RE: Request for Additional Information – MP08_0079 Mod 1

Appendix B – Revised Intersection Design

PROJECT NAME		DRAWING TITLE	
SRC ENTRY CONSTRUCTION AMENDMENT		CROSS SECTIONS	
PROJECT ADDRESS & DETAILS			
75 GRIFFEN ROAD, TERALBA			
FOLDER NO:	SHEET: 4 OF 6 SHEETS	DRAWING No:	VERSION DRAFT-D

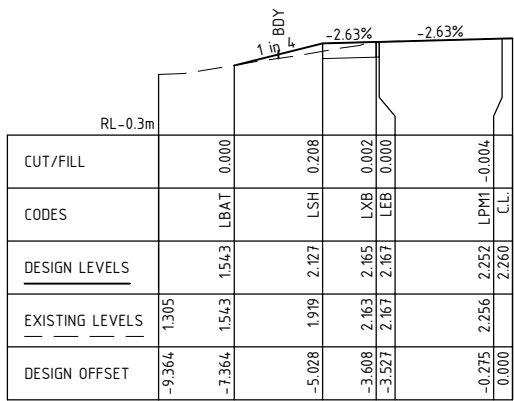
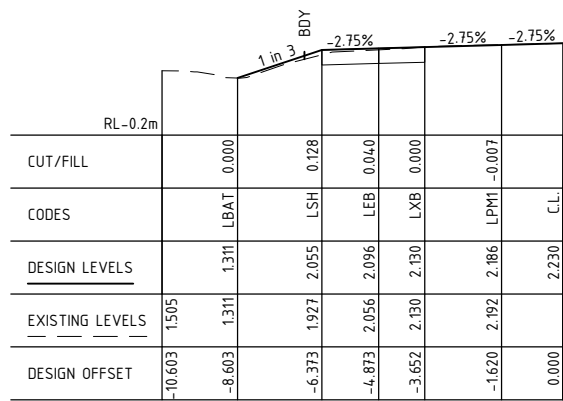
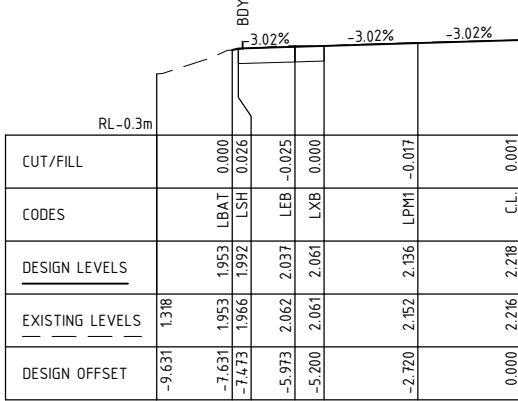
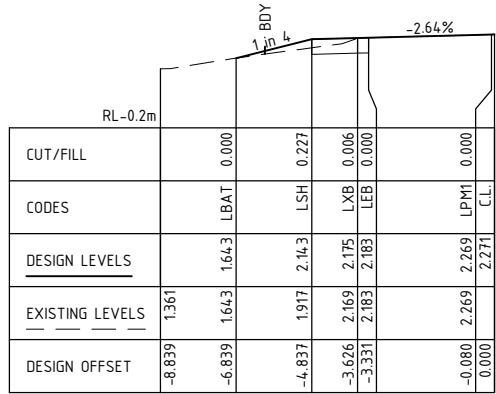
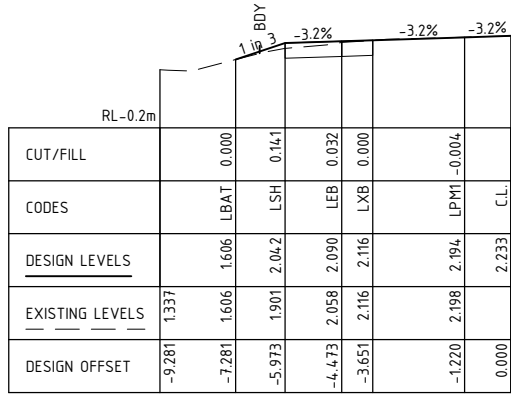
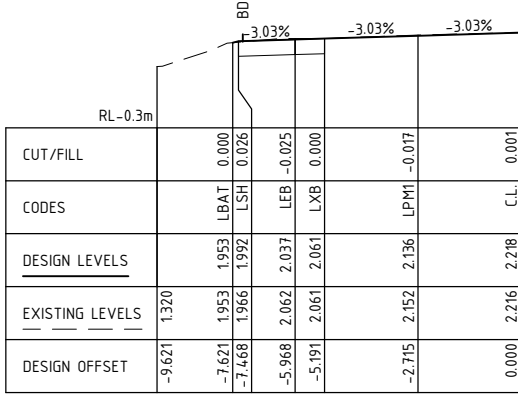
In discussion with Council, the decision was made to revise the intersection design to remove any impact on the referenced vegetation. To achieve this, the proposed batters supporting the intersection have been minimised where possible resulting in no vegetation requiring removal. A revised intersection design is provided in Appendix B.
